Mountain View Electric Association, Inc. (MVEA) has these comments about the following:

**Project Name: 824 Acres, Final Plat**

**Project Number: SF 1912**

**Description:** Approval is being requested for the Final Plat of Saddlehorn Ranch, Filing #1. This filing will consist of 53 residential lots on approximately 176 acres. The Final Plat and Preliminary Plan are being requested concurrently with El Paso County. This proposed subdivision is located east of Curtis Road and south of Judge Orr Road in Section 03 and 10, Township 13 South, Range 64 West.

SADDLEHORN RANCH FILING NO. 1  
JOB NO. 25142.01  
SEPTEMBER 2, 2020  
SHEET 3 OF 5

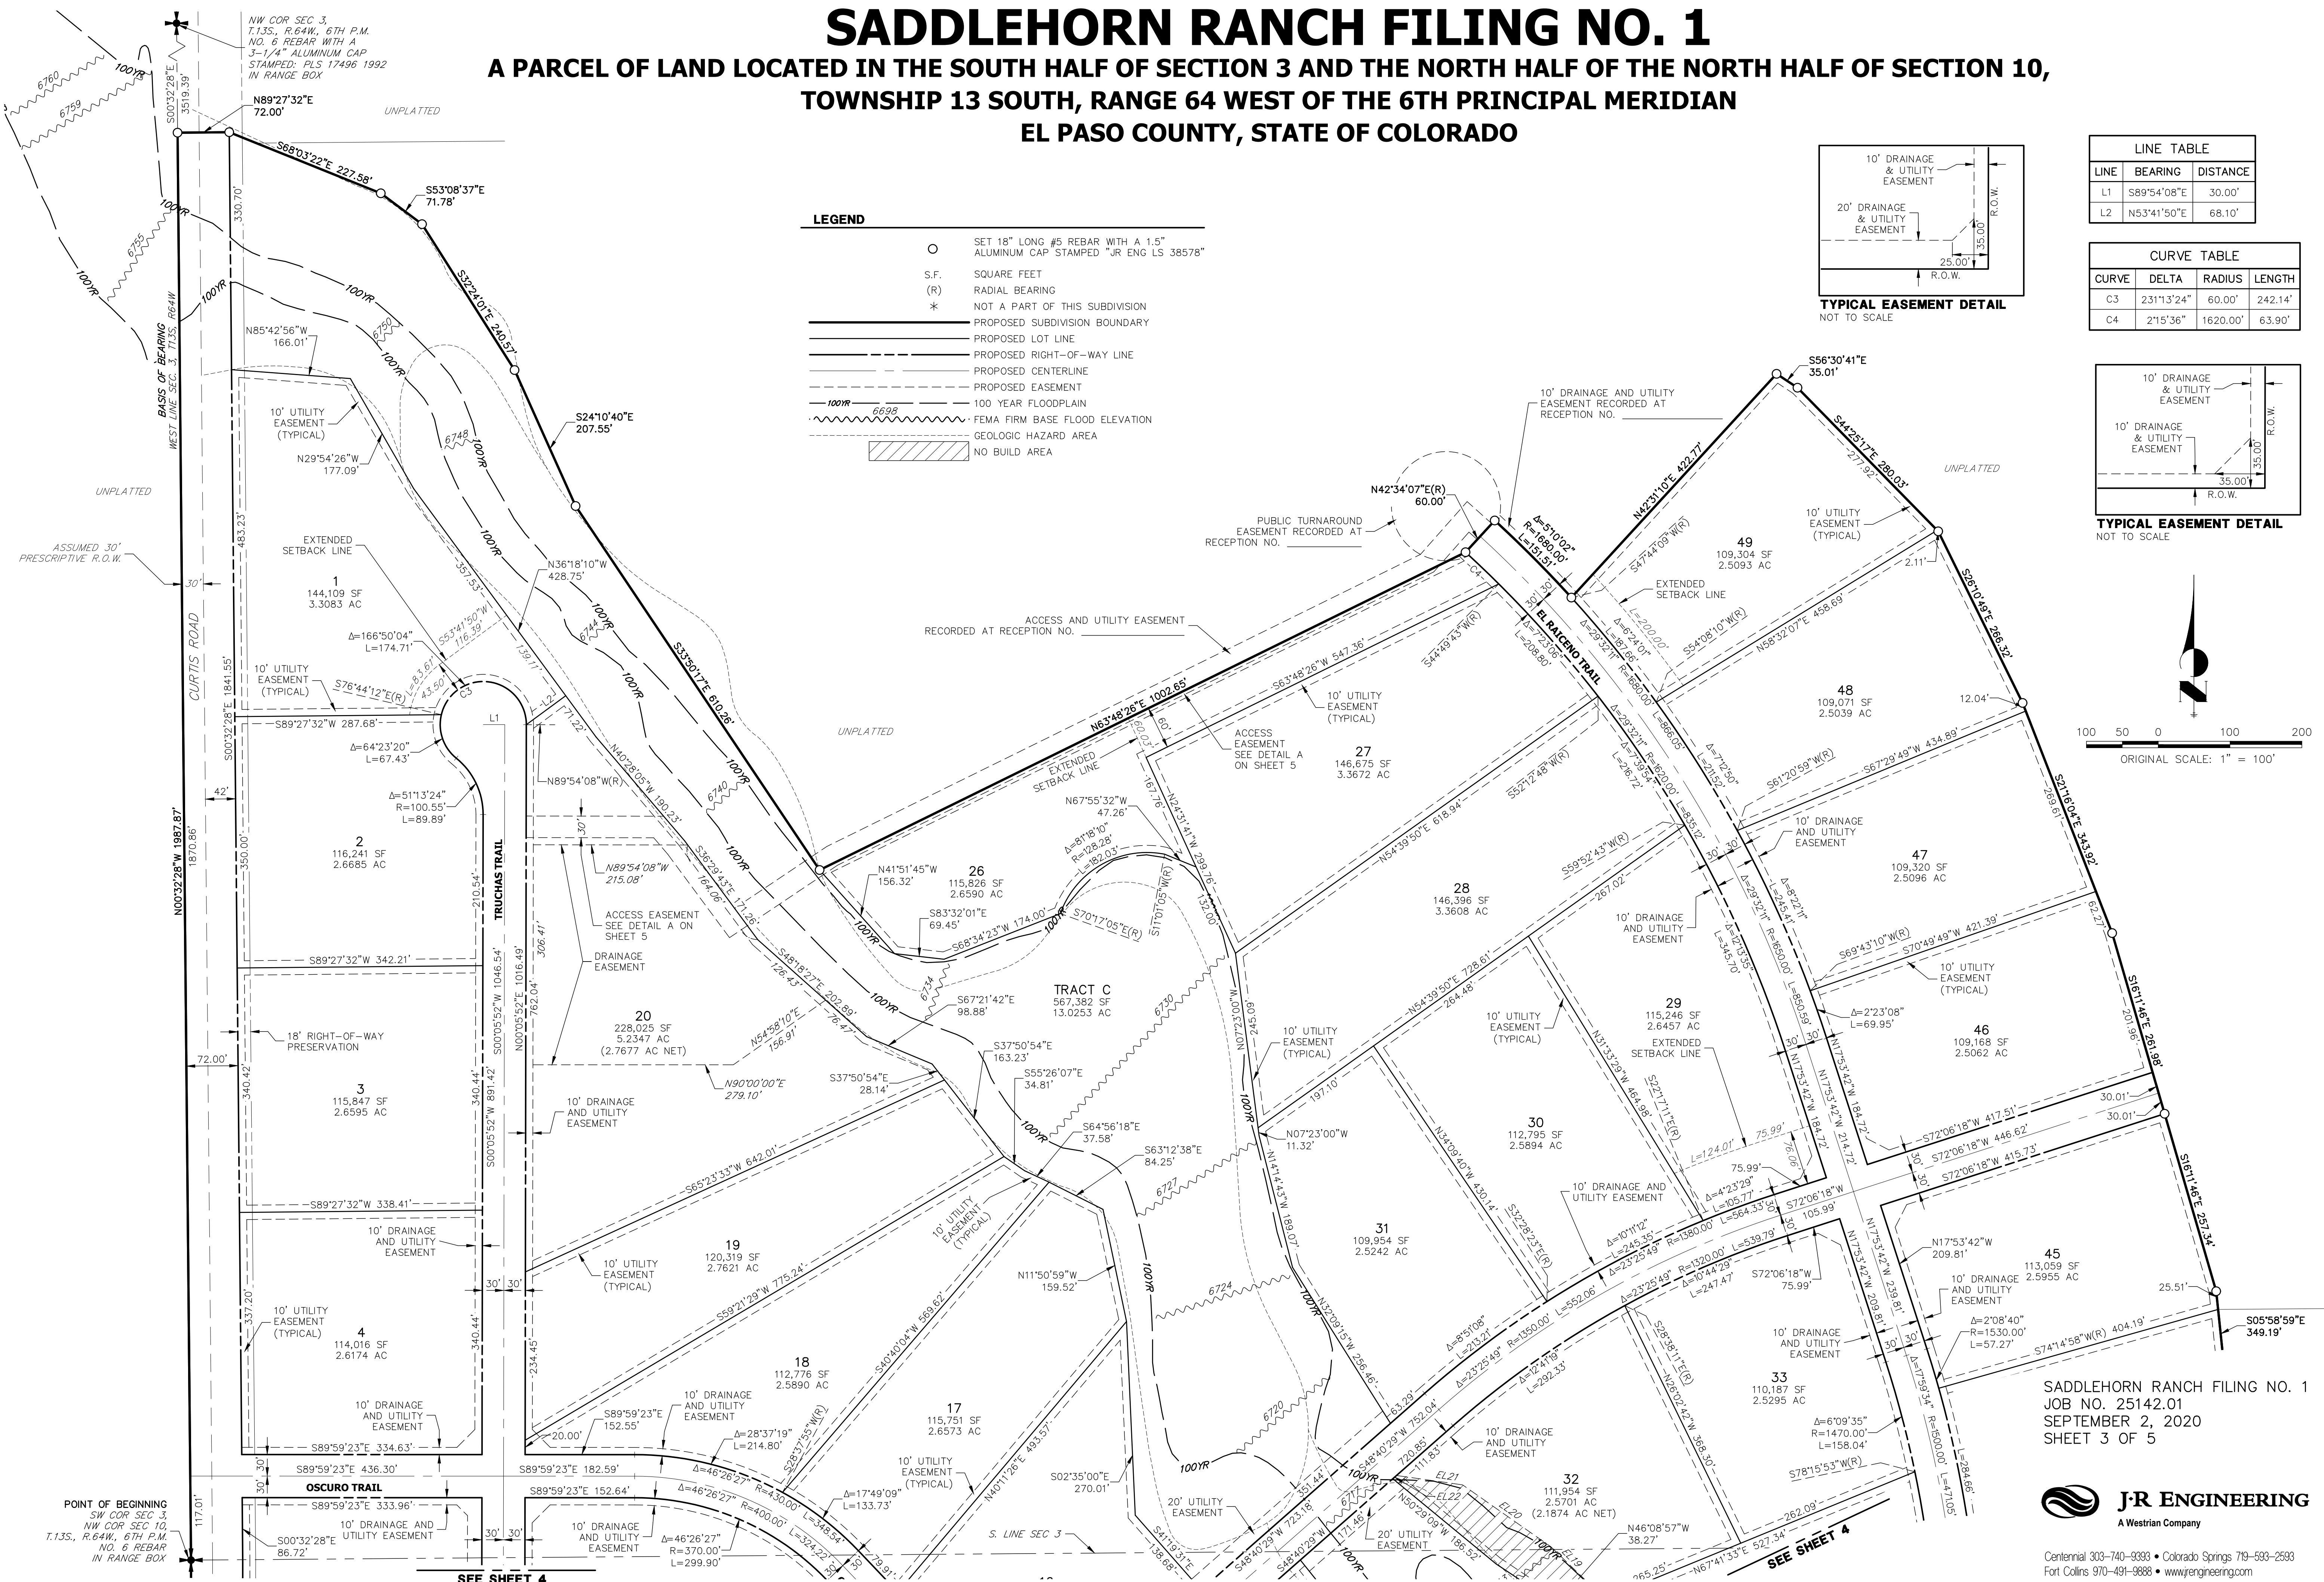
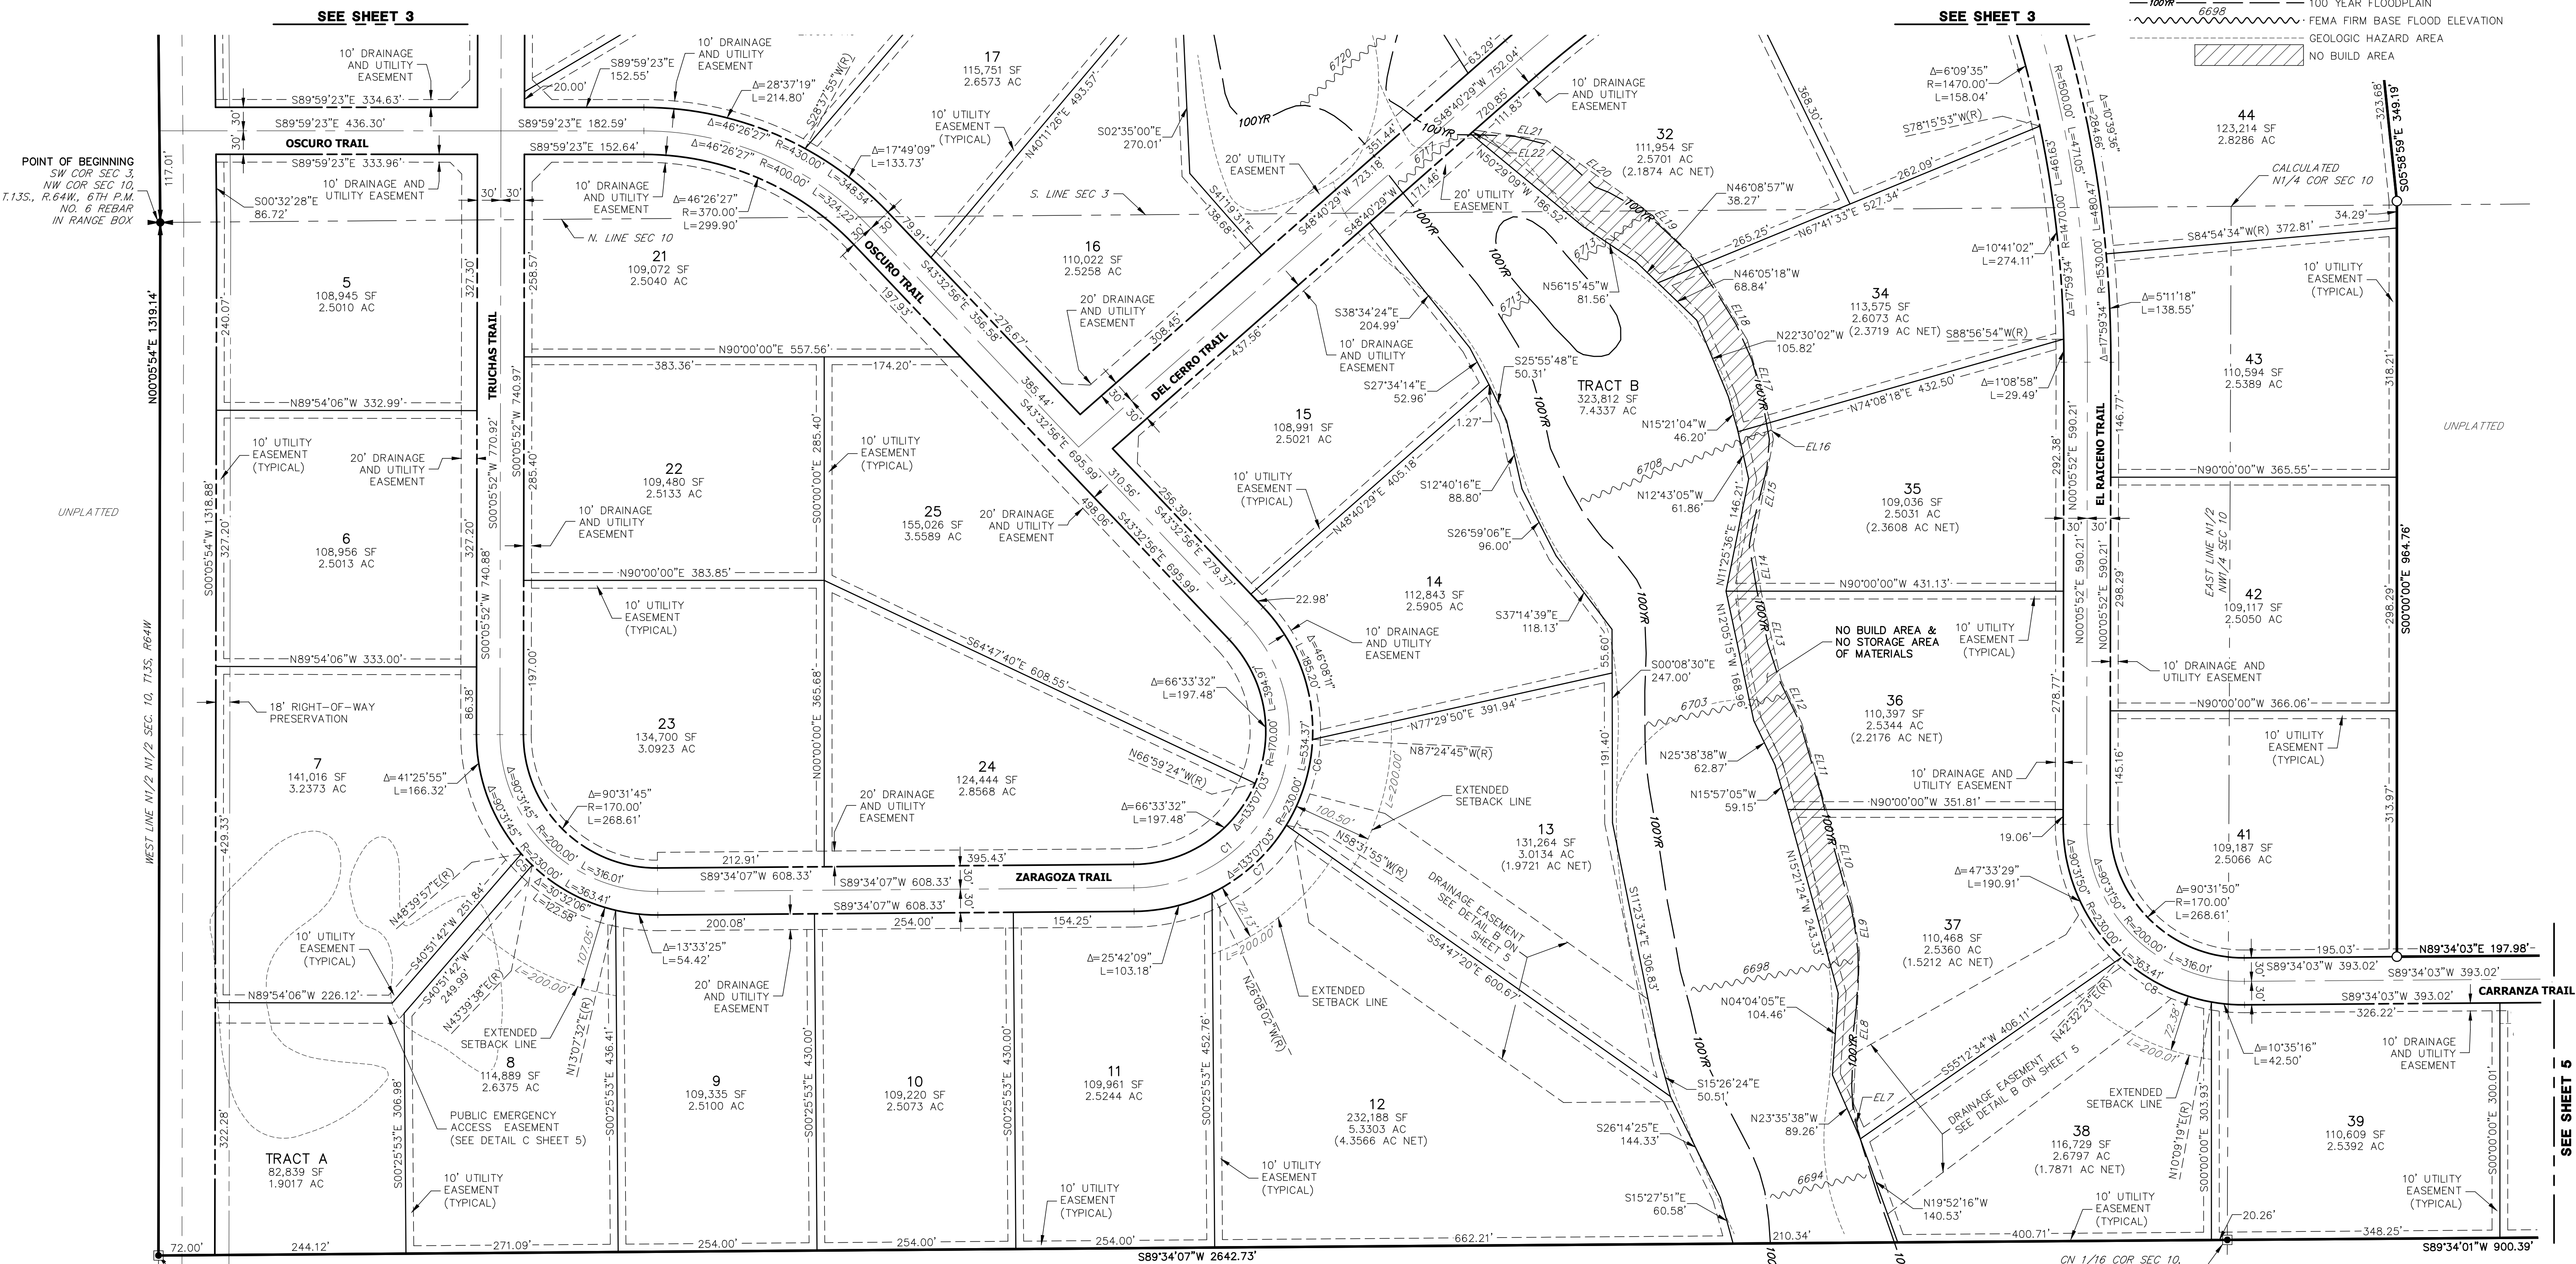
MVEA requests a ten (10) foot front, side and rear lot utility easement along with a twenty (20) foot exterior easement on plat. If open space, drainage and landscape tracts are designed in this filing MVEA requests these areas be listed to include utilities. Additional easements may be required once a review of civil drawings with grading and erosion plan is provided to MVEA in order to serve this filing.
